Response to Submissions Peppertree Quarry Modification 3

Prepared for Boral Resources (NSW) Pty Limited | 3 October 2012

Report J12053RP2 | Prepared for Boral Resources (NSW) Pty Limited | 3 October 2012

Figure 6: Heritage Management Area and Proposed Offset Area

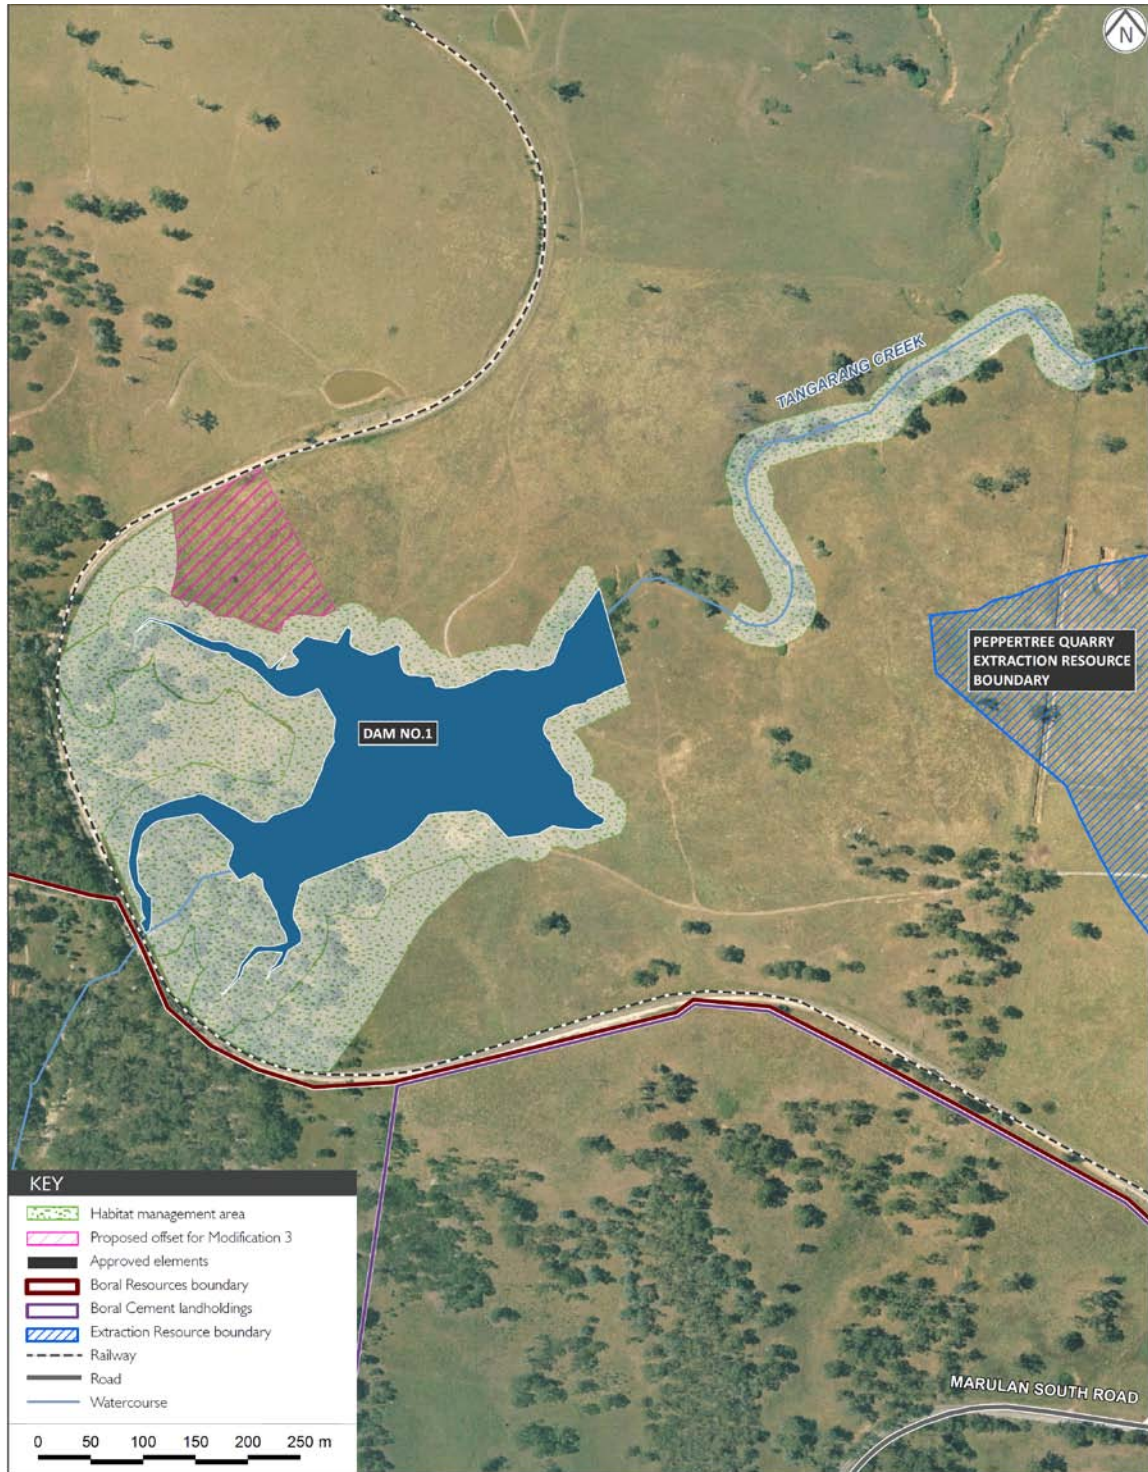
OEH acknowledge the route of the HCV power line has been chosen to avoid all large hollow bearing trees, however the route will still impact on regenerating areas of the Endangered Ecological Community "White Box Yellow box Blakely's red gum woodland". The route attempts to avoid significant impacts and may mitigate these impacts, however the current proposal of spraying the class 4 noxious weeds within the surrounding areas is not considered to be an adequate offset for the impacts of this development. Spraying of weeds such as Serrated Tussock and St John's Wort is a legal requirement of all landowners under the Noxious Weeds Act and is therefore required to be undertaken and cannot be considered an offset for this development. OEH note the area where the HV power line route will impact is surrounded by intact Box gum woodland. The proponent could consider investigating the protection or enhanced management of this area as an offset for this development. Such enhanced management should be above and beyond what is required by legislation such as the Noxious Weeds Act.

In addition to the above measures previously proposed, the proponent will further offset the impacts of the proposed modification by the inclusion of an additional 1.5 hectares (ha) of land to enhance the existing Habitat Management Area (HMA) (approved under PA06_0074). The approved HMA is shown on Figure 2.1, as well as the additional 1.5 ha proposed as an offset for this modification.

The proposed offset area adjoins the HMA and is previously cleared, grazed land. It is intended that it will be rehabilitated to Box-Gum Grassy Woodland, providing an overall increase in the local extent of the endangered ecological community of more than 1 ha. This equates to an offset ratio of 3:1. Given that the area to be impacted is considered to be of low importance to the conservation of the Box-Gum Grassy Woodland within the local area and within the region, and that only a small area of the ground cover and a limited number of trees will be impacted, an offset ratio of 3:1 is considered more than adequate to compensate for the impacts of the proposed modification.

Figure 7: Archeologically Sensitive Area

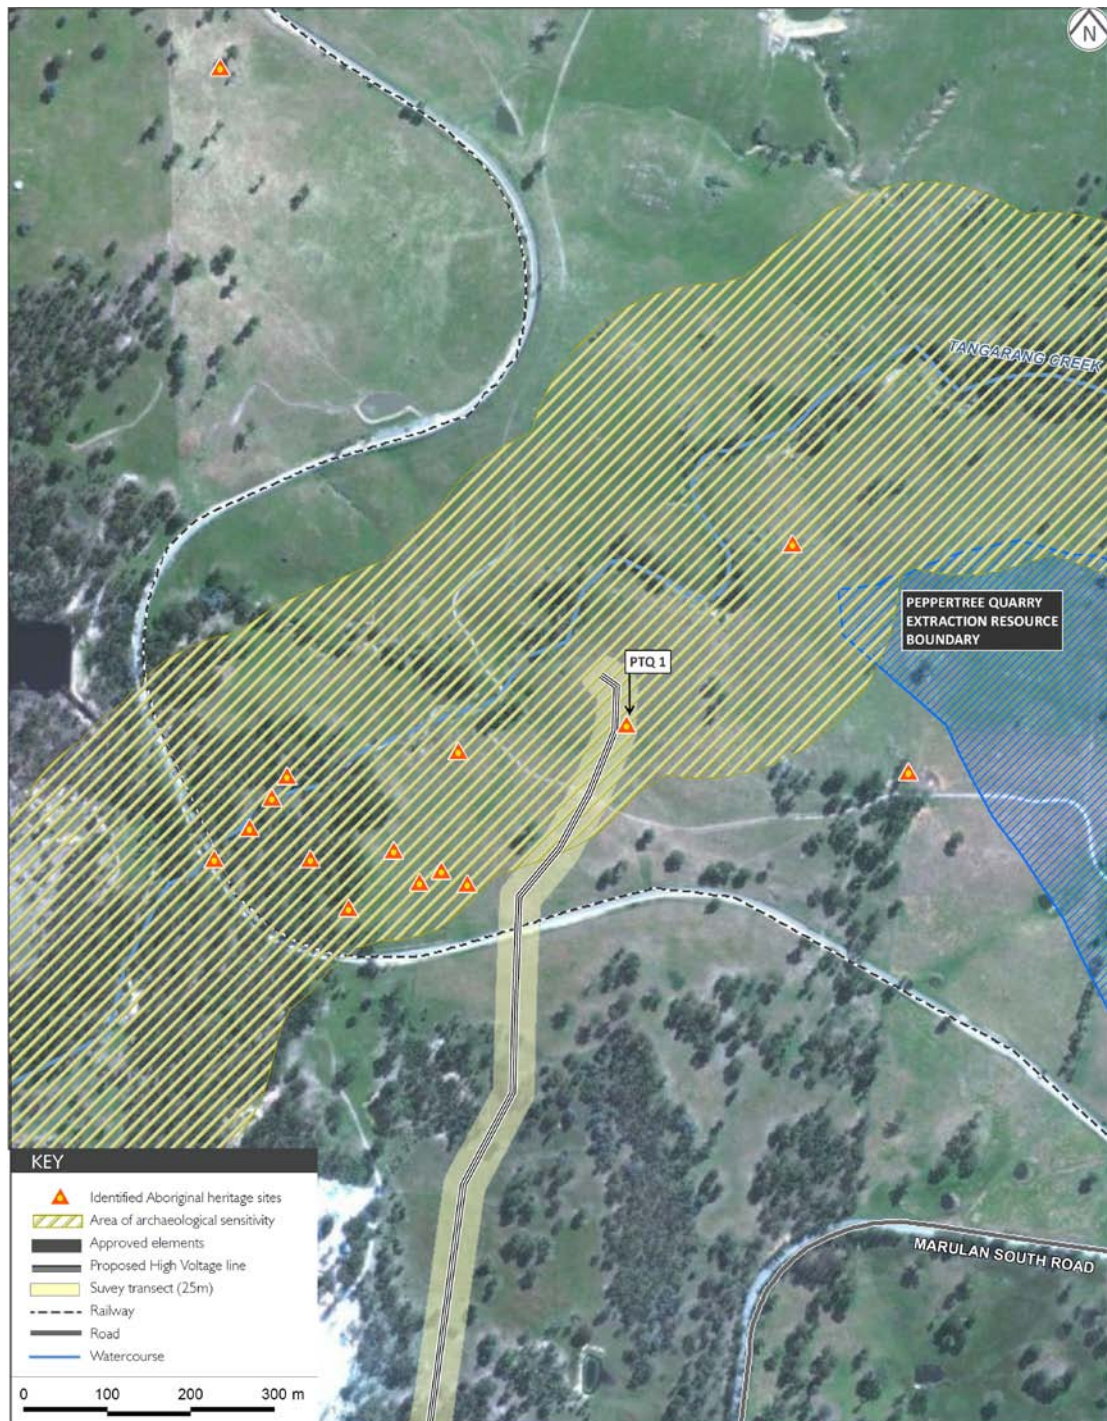
The report recommendations are not consistent with OEH policy as they include a recommendation that works should be monitored by Aboriginal community representatives, where monitoring may not be the best outcome for protecting and understanding ACH values. Often monitoring only results in the discovery of Aboriginal objects (including Aboriginal skeletal remains) after they have been disturbed. Instead OEH suggests that a program of subsurface testing to refine the predictive model for site and artefact locations could be undertaken before construction commences.

The northern portion of the HV line will pass through a small portion of land defined as sensitive through previous archaeological studies (ERM 2006) due to its location within 200 m of Tangarang Creek. Consistent with Project approval conditions this area was subject to archaeological excavation under controlled conditions. This has created a rich archaeological and cultural record for Aboriginal heritage in Tangarang Creek and its surrounds. Subsequent to this excavation season, the area which the HV line will pass through was disturbed by previously approved construction activities.

In addition to the measures already completed by the proponent, design changes to the HV line have been made to reduce impacts to Aboriginal heritage near Tangarang Creek. The power poles PP14649, PP14650, PP14648, PP14647 have been moved closer to previously disturbed areas, further reducing the potential for Aboriginal objects to be disturbed. This is the maximum distance the power poles can be moved as the HV line will pass between a rail line already under construction and a dam. As a result the construction corridor for the HV line affects a minor proportion of the inferred artefact distribution. The total area of sensitivity estimated for the Tangarang Creek land is 6 km² (600 ha). The estimated area of the HV line corridor, allowing for a 25 m wide corridor is 2.7 ha (25 m x 1,080 m) which is 0.45% of the sensitive area. Impacts to Aboriginal heritage are further reduced as ground disturbance will only occur at the pole locations. These factors combined with the low impact of the HV line mean that subsurface testing or further excavation was not warranted in this instance and monitoring considered appropriate.

HV line construction works
Peppertree Quarry - Modification 3
Figure 3.2

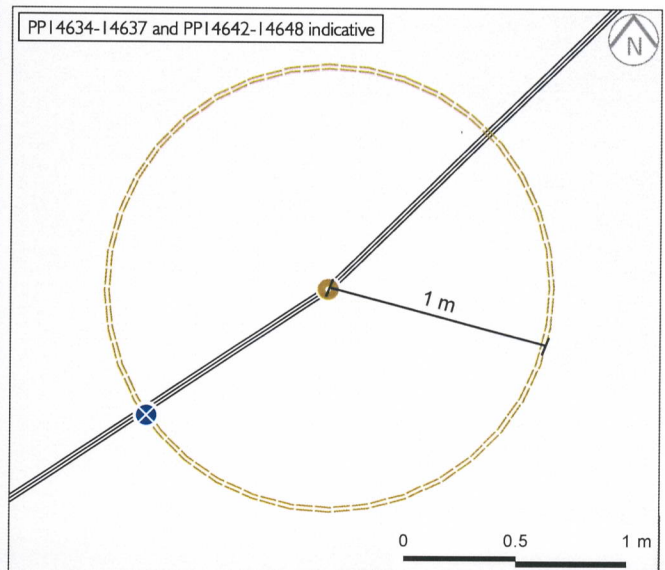
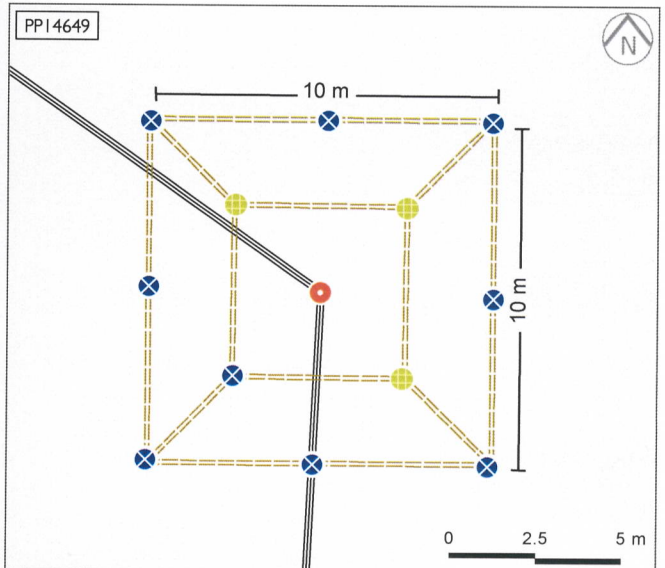
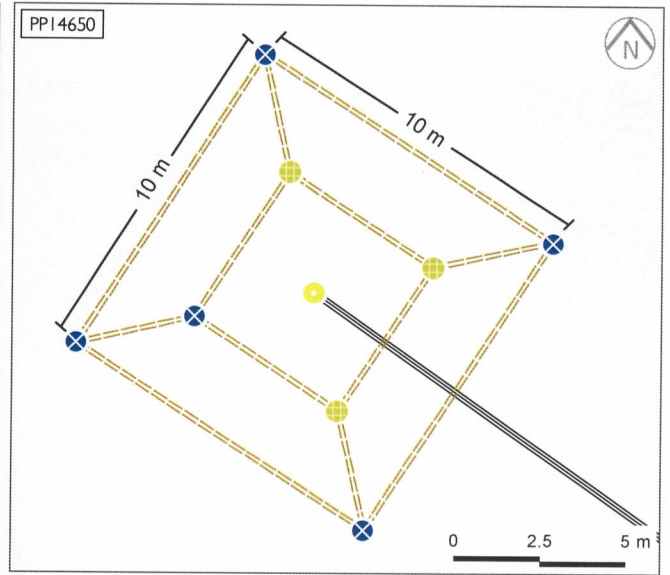
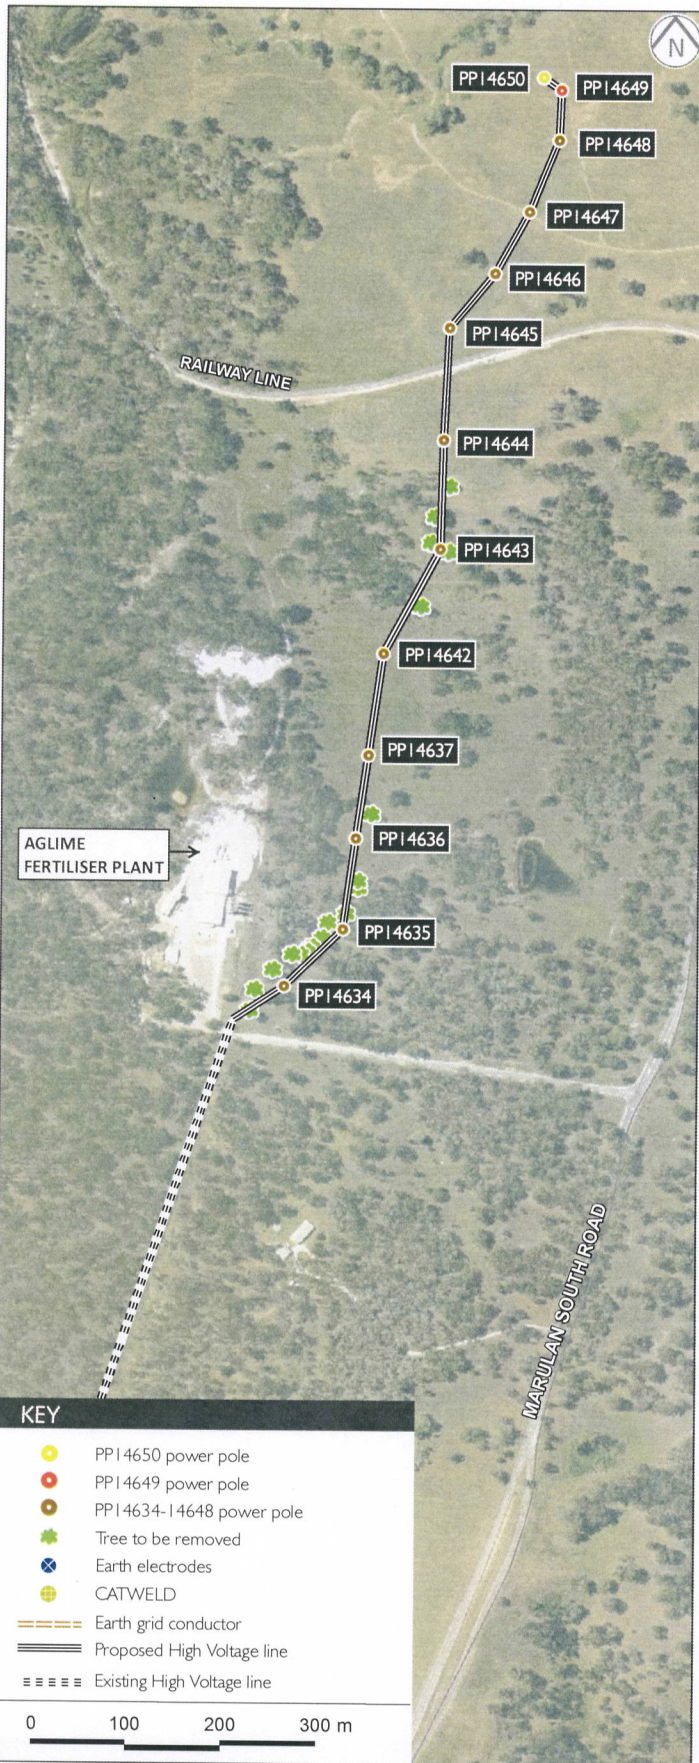
Documentation of the survey strategy and survey units does not meet the requirements stipulated in the 2005 guidelines. For example, the report contains no map that shows the boundaries of the survey units and the route(s) of the survey transects within each unit. There is also no information on survey transect widths. This information is required to calculate effective survey coverage and is a requirement listed in the 2005 guidelines.

Survey units must be based on recognised landscape and/or landform units. The units described in the EA do not meet the criteria discussed in the 2005 guidelines.

The survey covered all areas to be impacted. A map detailing the survey units and their routes is included on Figure 2.2. Survey transects for the HV line were walked by four people spaced approximately 5 m apart resulting in a survey transect width of 20 m. A detail of this survey transect is provided in Figure 2.3. This width is more than sufficient to cover the proposed areas of ground disturbance for the HV line, which are limited to the pole locations. The width of the transect covering the passing line extension was narrowed to 10 m in width due to the nearby location of the railway tracks.

The landforms of the study area are shown in Figure 2.2. Survey units were located on one landform; flat. Flat ground is defined as broad areas with no evidence of defined slope, defined undulating slopes or valley edge ridges.
